Application for Approval of Details Reserved by Condition

Proposed enlargement of Car Park B to create 15 additional designated parking bays;
Remove planting bed adjacent to existing disabled parking bay to provide two sideby-side disabled parking bays; Provision of three new cycle shelters, providing space for 18 bicycles along the main school entrance walkway.

3/2024/1020

Condition No.4 - Proposed landscaping
Condition No.5 - Landscape/habitat management and monitoring plan
Condition No.7 - Details of an alternative secure cycle storage

Project		
St Cecilia's RC High School Longridge		
Title		
Proposed Parking Plan		
Scale	1:200 @ A3	Date 20.11.24
Drwg No	4974 /P04A	Drawn

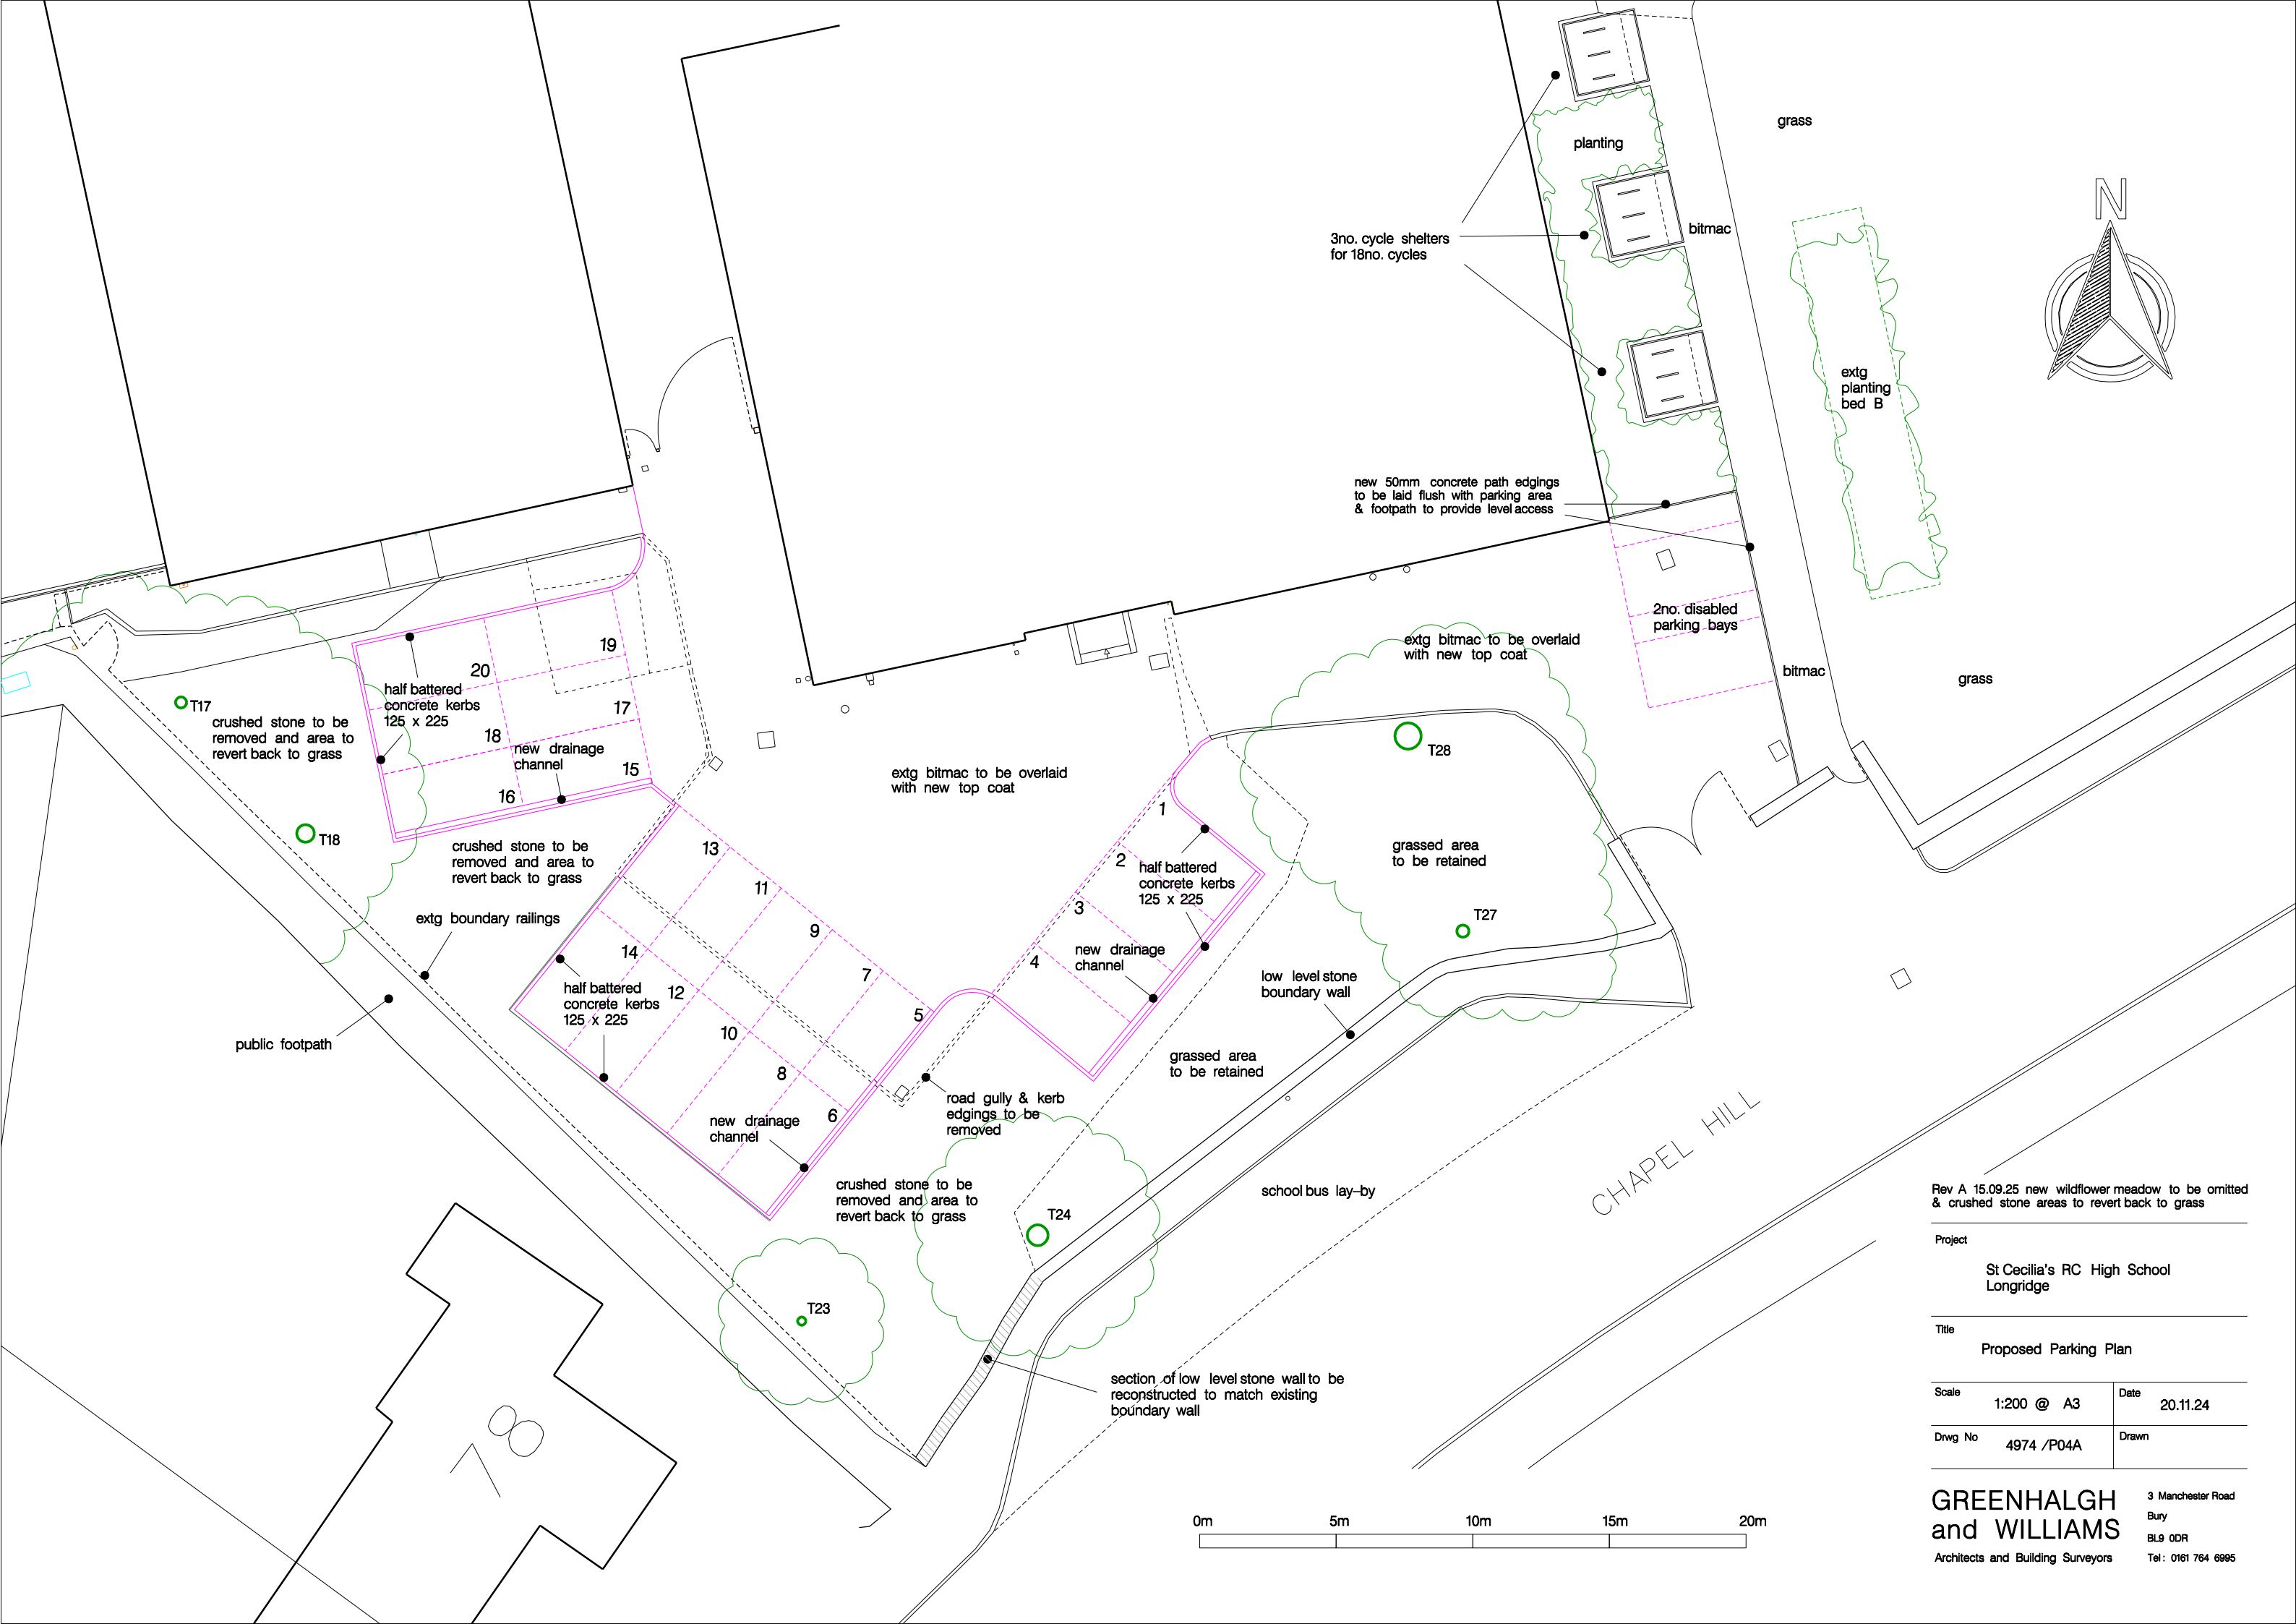
To meet the mandatory 10% Biodiversity Net-Gain (BNG) requirement the proposal was to provide a wildflower meadow surrounding the proposed enlarged car park to the front of the school with 3no. additional trees located elsewhere on the school site.

The planning authority consider that as the wildflower meadow would need to be left wild for the majority of the year its appearance will harm the character of the site and surrounding area and as such an alternative landscaping scheme has been prepared.

In consultation with the appointed ecological consultant the school has decided to meet the BNG requirement by planting 12no. trees in addition to the 3no. already in the scheme. The location of the new trees is to be along the western boundary of the school playing field adjacent to Preston Road and north of the residential properties. The trees are to be set 3m in from the perimeter mesh fencing and 3 to 4m apart. The new trees are to be approximately 3m tall with a minimum 38mm stem. The area surrounding the new extended car park will revert to mown lawn.

4974 /P05B

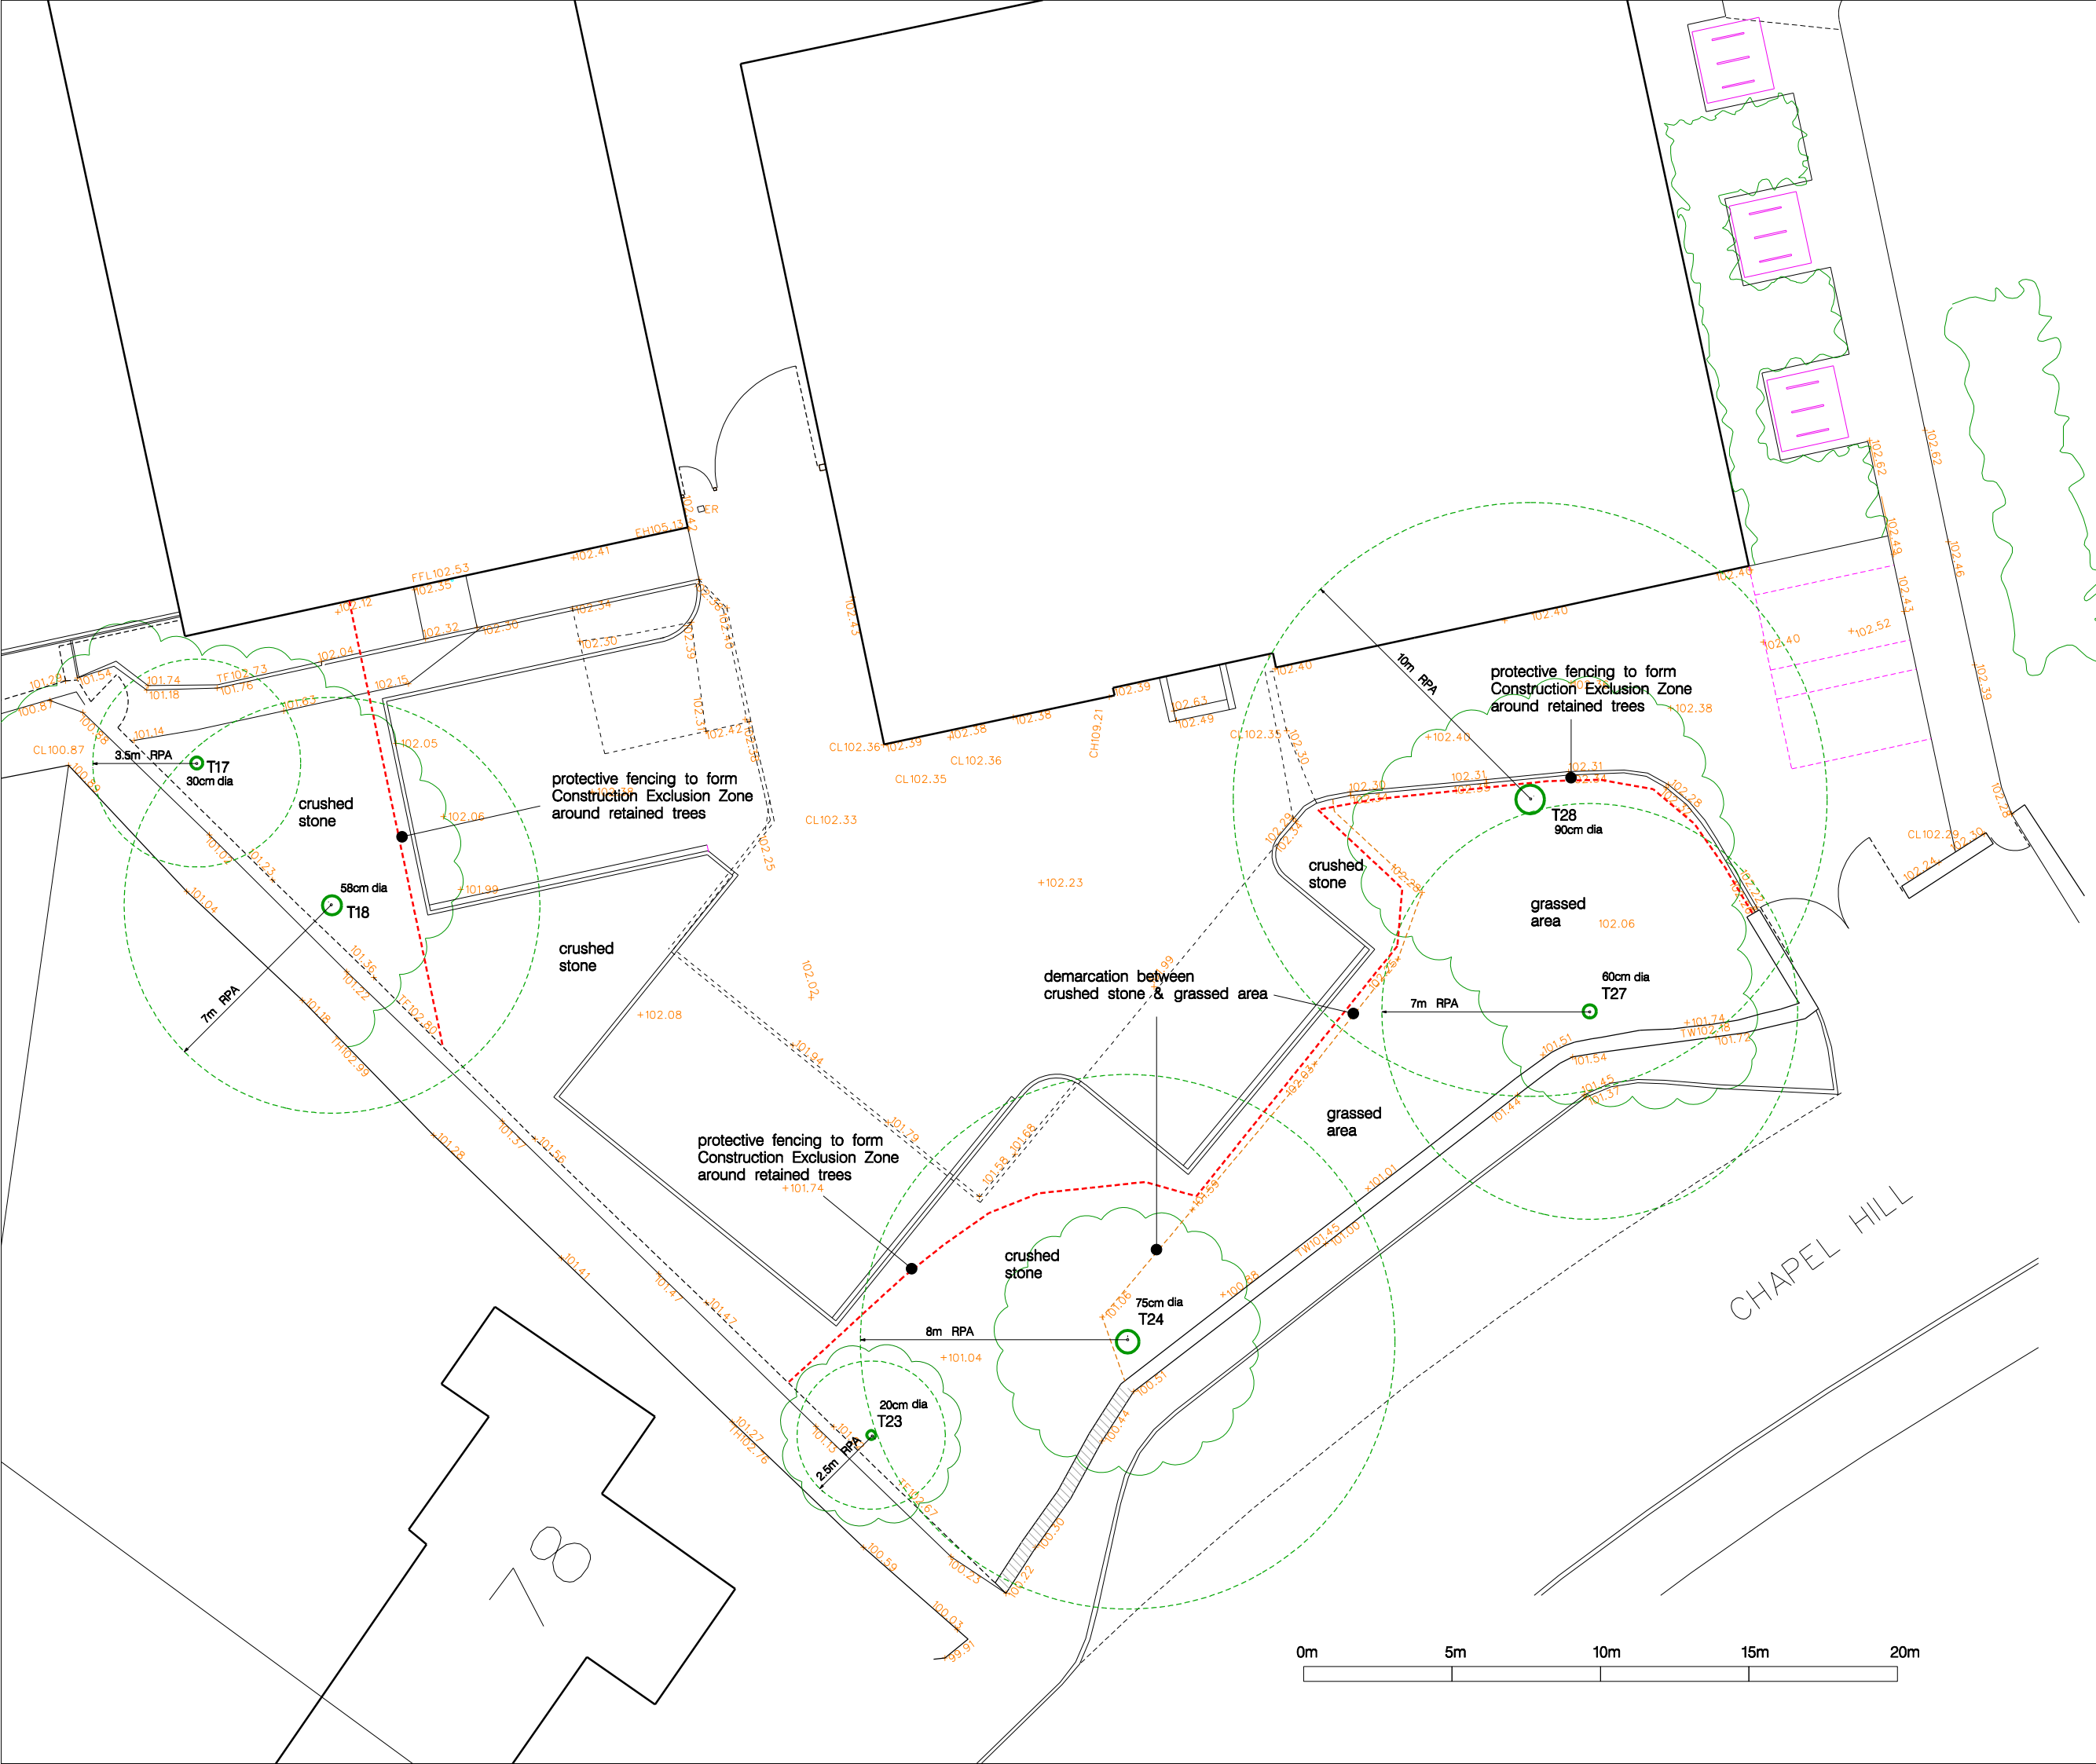
The planning authority has requested that additional details of the proposed landscaping are prepared including details of the further details of the measures to be undertaken to protect all trees and hedgerows within the vicinity of the works.

4974/P05B Tree Protection Plan
